Addendum No. 2

RE: Contract # C204902
WBS # 15BPR.102.3
STATE FUNDED
New Hanover County
CAPE FEAR MEMORIAL BRIDGE.

Page No.	Revision
Proposal Cover	Note added that reads "Includes Addendum No. 2 Dated 11-17-2023".
BP-26	The Structures Unit Project Special Provision entitled REPLACEMENT OF STRUCTURAL STEEL has been revised. New paragraph added to the "Material" section.
BP-37	The Structures Unit Project Special Provision entitled NOTES TO CONTRACTOR has been revised. New paragraph added to the end of the NOTES TO CONTRACTOR provision.

STRUCTURAL STEEL FLOORBEAM DETAILS

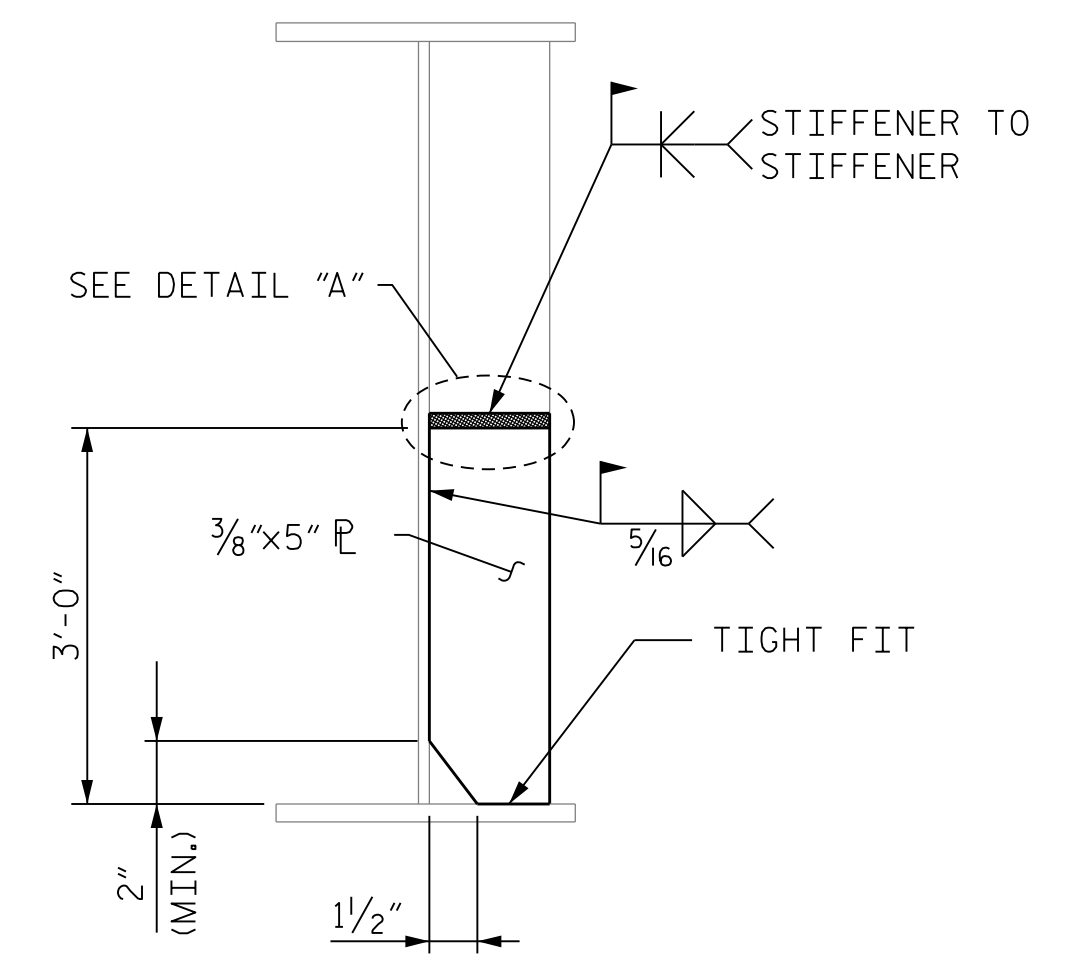
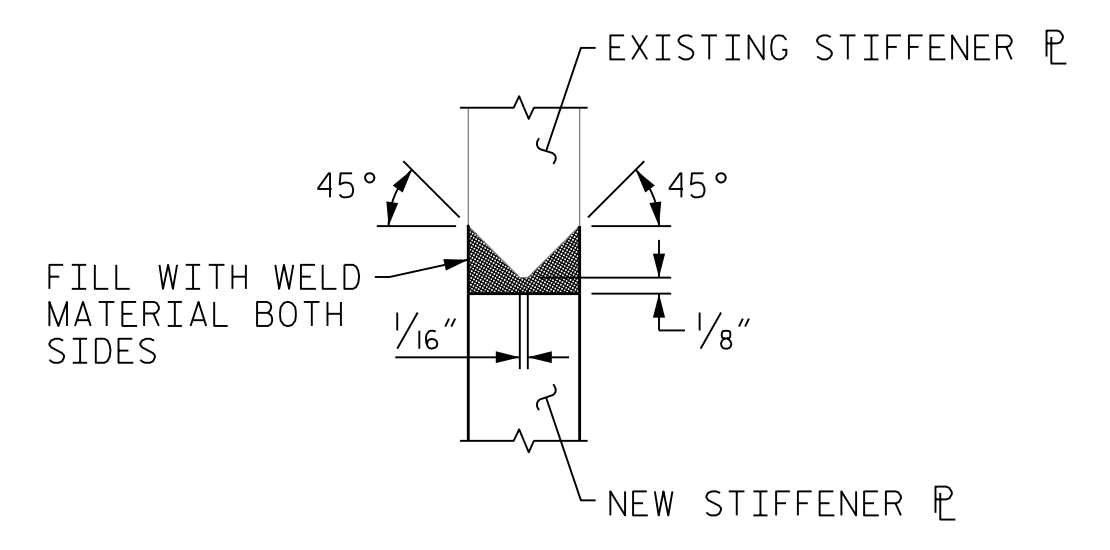
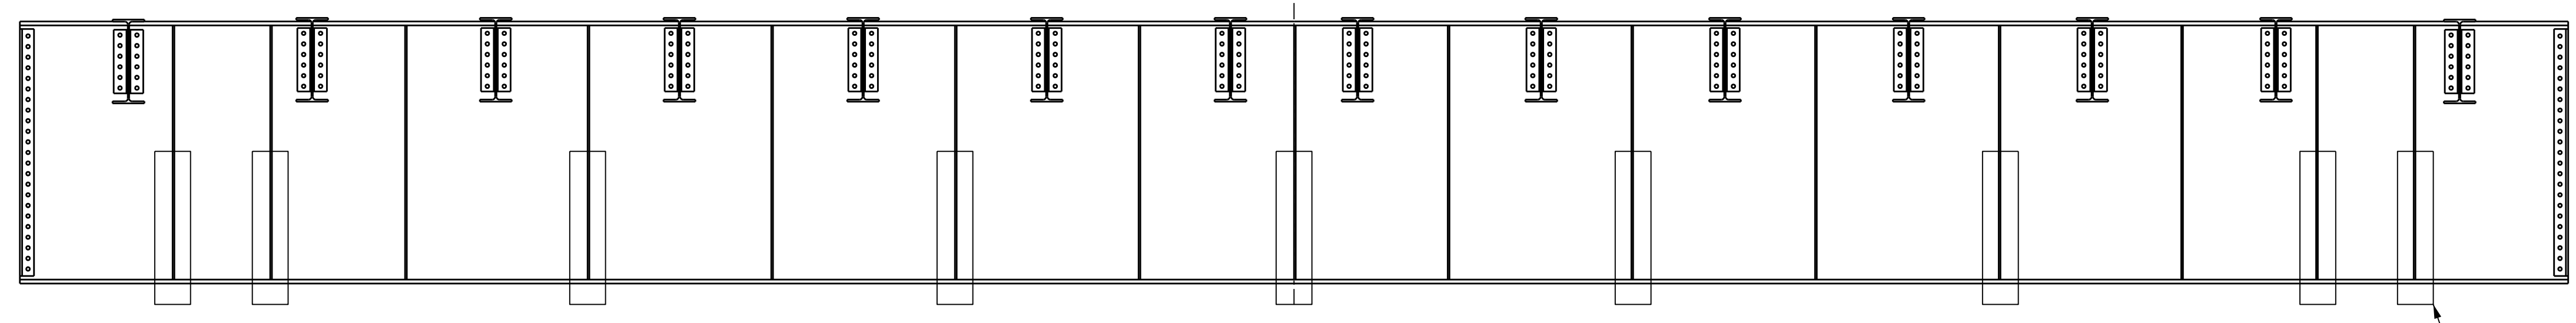
Working Drawings are required for any Structural Steel provided by the Contractor, which includes the finger plate shims and may include the floorbeam stiffeners, if the Contractor chooses to remove a different height of the stiffeners than is shown in the suggested details. Working Drawings are required for span balancing plates to be used by the Contractor.
